Arun District Council
Development Control
Arun Civic Centre
Maltravers Road
Littlehampton
West Sussex
BN17 5LF

Our ref: HA/2022/123981/04-L01
Your ref: BN/11/22/OUT
Date: 13 February 2024

OUTLINE APPLICATION WITH ALL MATTERS RESERVED (EXCEPT FOR THE A29 REALIGNMENT) FOR THE DEMOLITION OF EXISTING STRUCTURES AND MIXED USE DEVELOPMENT TO PROVIDE UP TO 1,250 RESIDENTIAL DWELLINGS (USE CLASS C3), CARE HOME/SENIOR LIVING ACCOMMODATION (USE CLASS C2/C3), FLEXIBLE RETAIL AND COMMUNITY FLOORSPEACE (USE CLASSES E/F2/SUI GENERIS), A PRIMARY SCHOOL PLUS OPEN SPACE, LANDSCAPING, DRAINAGE AND ALL OTHER ASSOCIATED ANCILLARY WORKS; AND REALIGNMENT OF THE A29 AND EARLY CONNECTION TO EXISTING A29 INCLUDING CONSTRUCTION OF A NEW ROAD CARRIAGEWAY, JUNCTIONS AND ASSOCIATED INFRASTRUCTURE. THIS APPLICATION ALSO LIES WITHIN THE PARISH OF ALDINGBOURNE, AFFECTS THE SETTING OF LISTED BUILDINGS, AFFECTS THE CHARACTER & APPEARANCE OF THE EASTERGATE CHURCH LANE CONSERVATION AREA AND AFFECTS A PUBLIC RIGHT OF WAY. THIS APPLICATION IS THE SUBJECT OF AN ENVIRONMENTAL STATEMENT. BARNHAM, EASTERGATE, WESTERGATE BEW PARCEL SC1 BARNHAM

Appendix B – General Arrangement for 30m Single Span Option

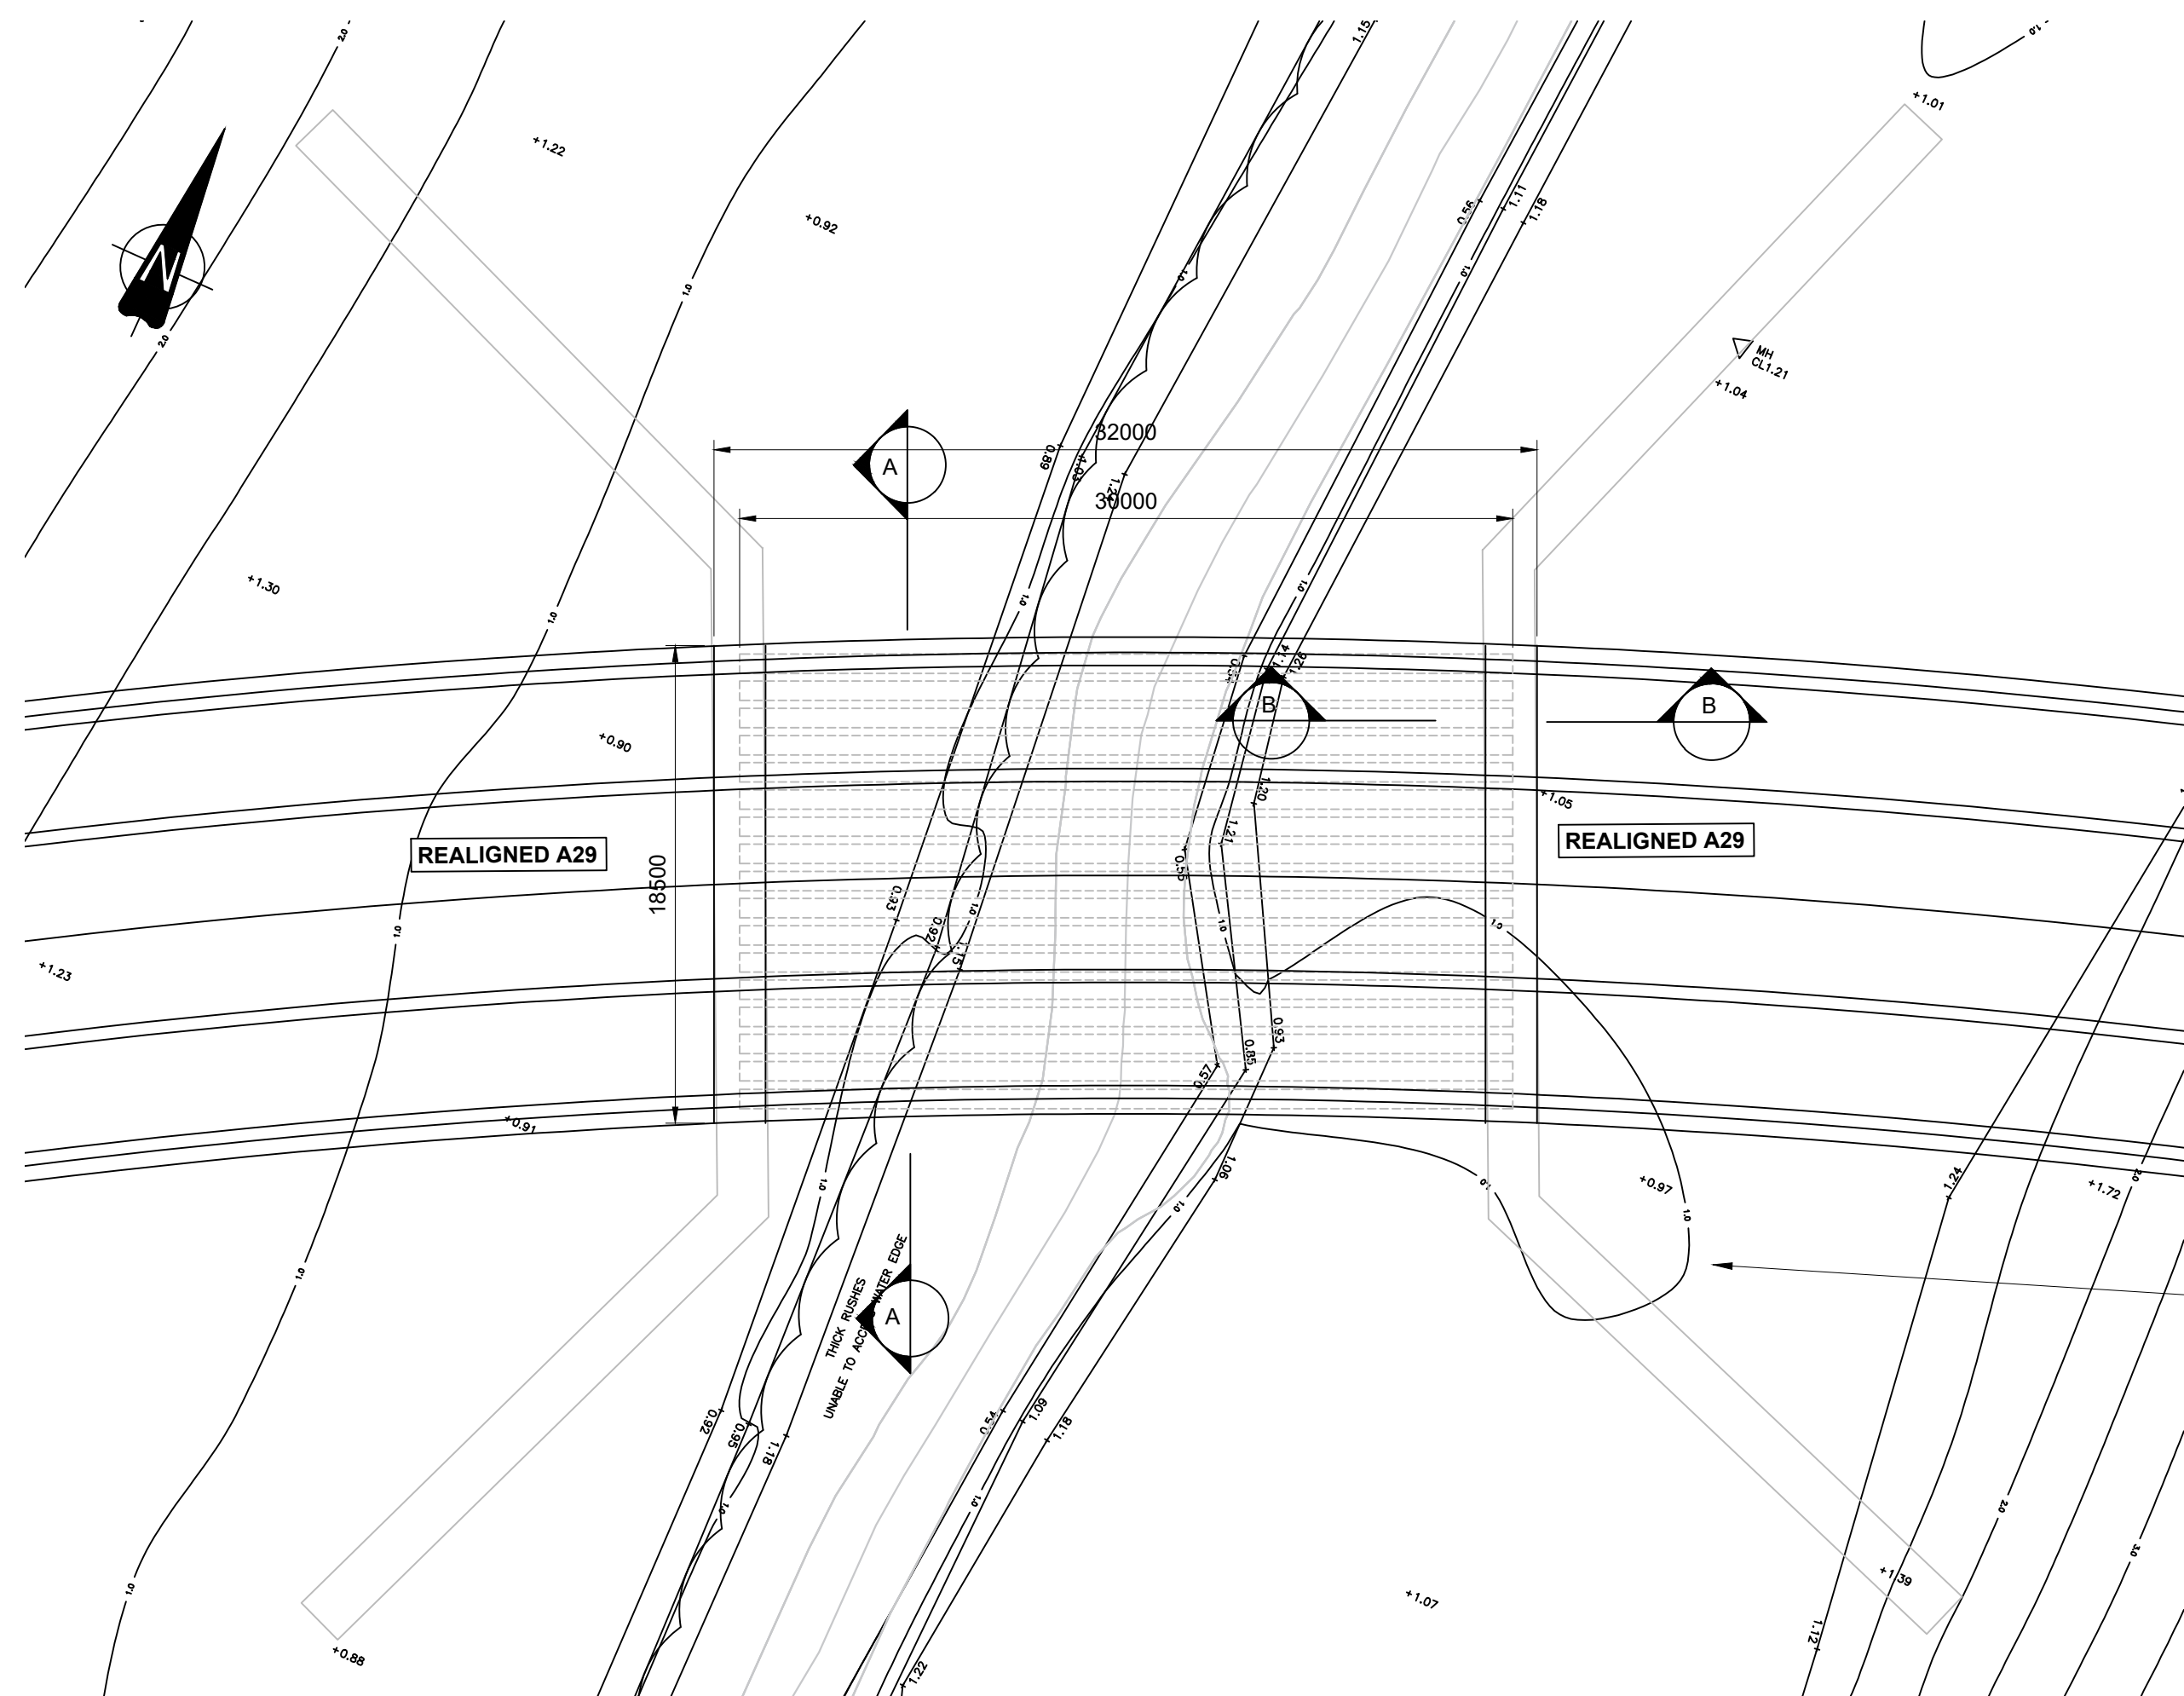
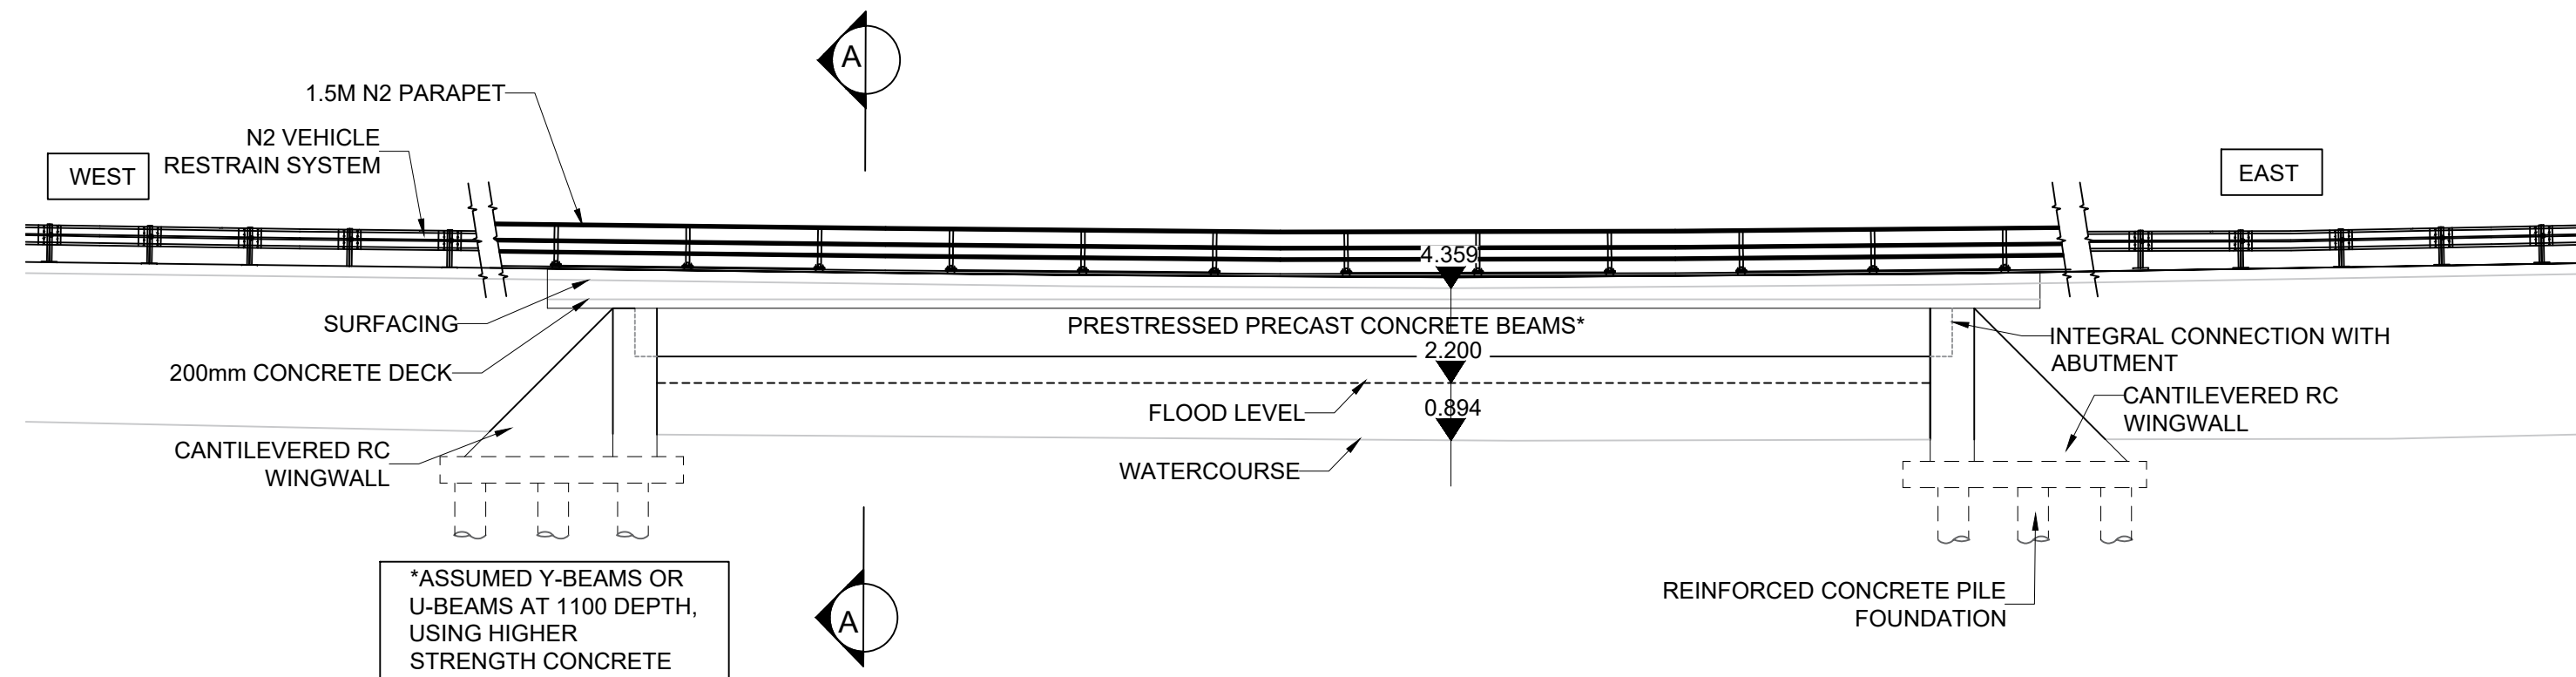
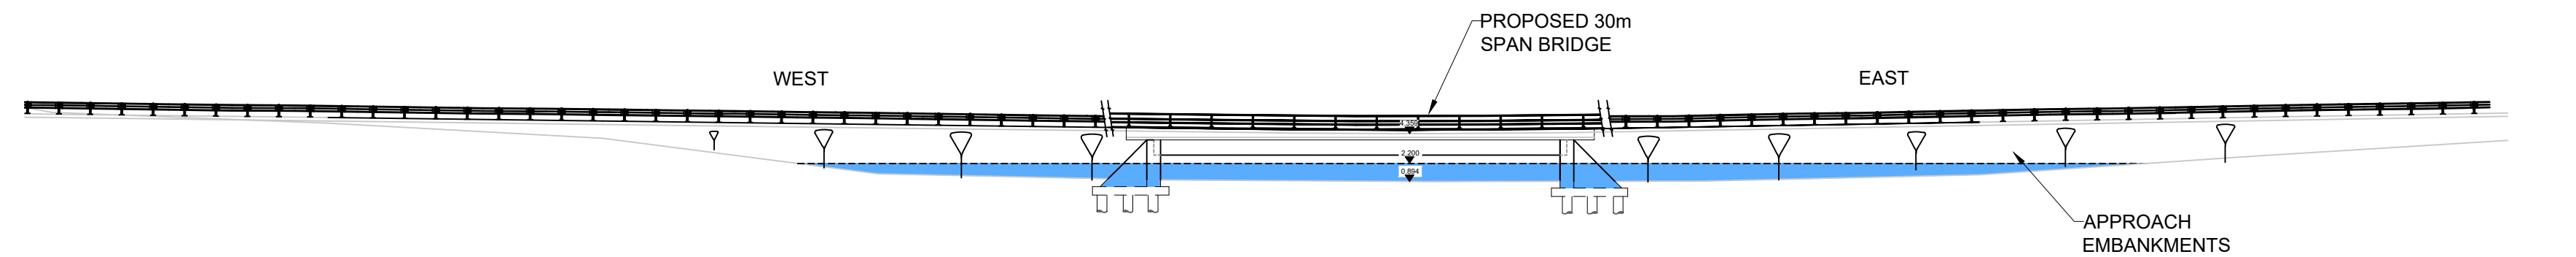
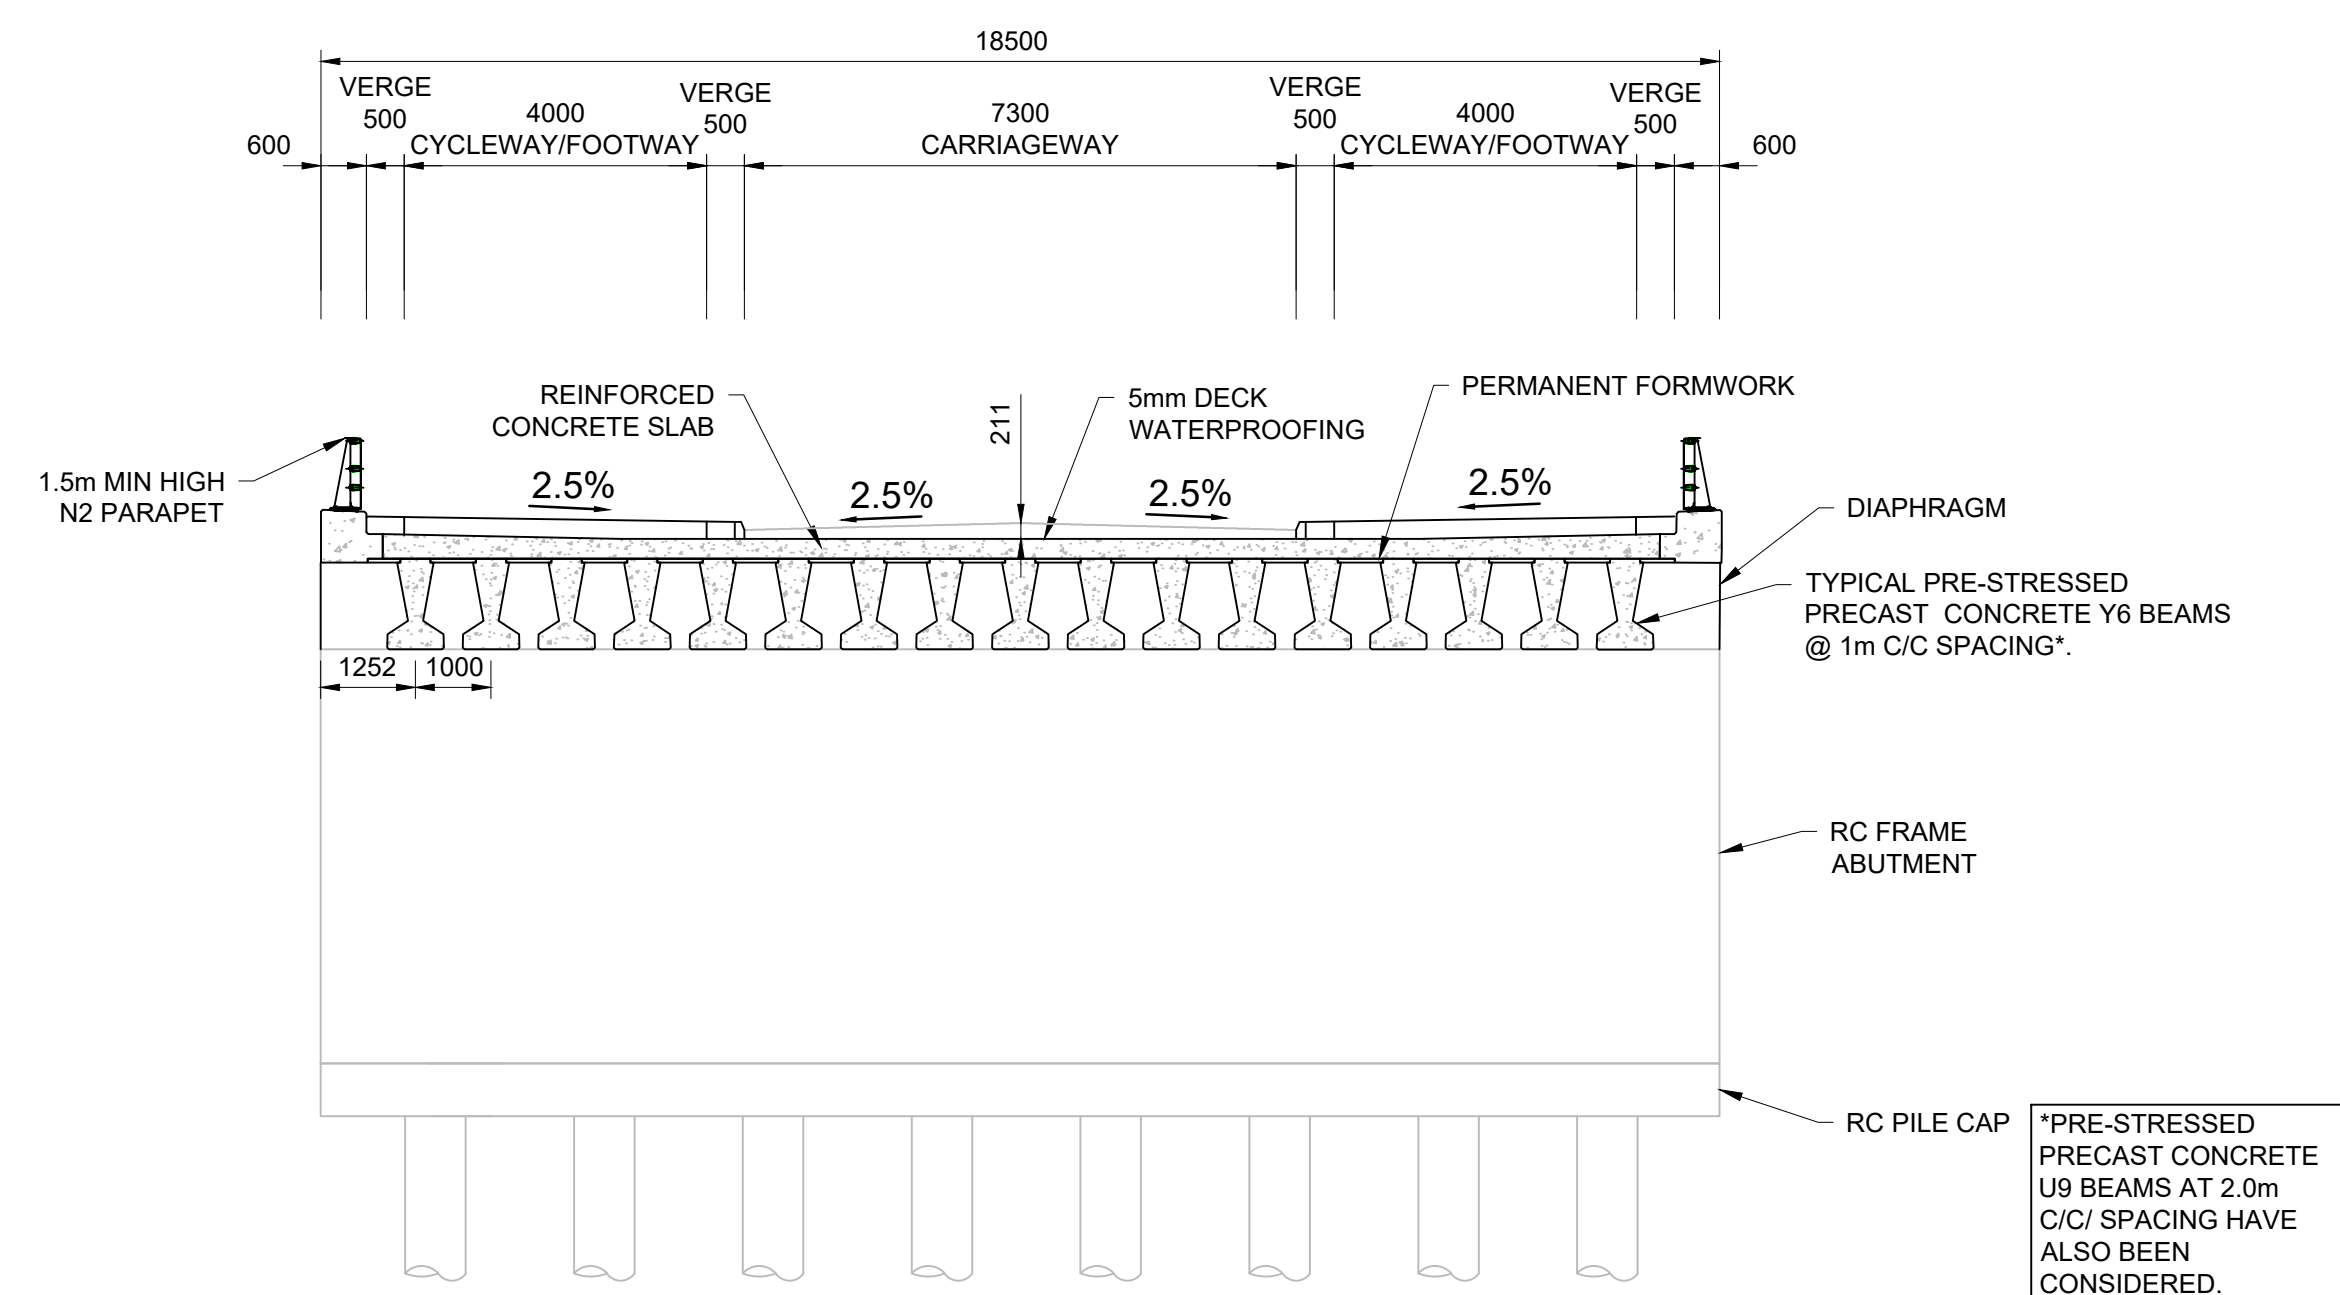
- All residential development shall take place in Flood Zone 1 only.
- The Lidsey Rife channel crossing shall have a minimum 30m clear bridge span, as set out in the modelled design parameters approved by the Environment Agency. The soffit level of the crossing shall be set no lower than 2.8mAOD.
 - Any changes in this design prior to construction will be sent to the Environment Agency for approval.
- At least 2,768m³ compensation shall be provided on a level-for-level basis on the western banks of the Lidsey Rife, as indicated in Table 5.1 of the above Flood Risk Assessment.
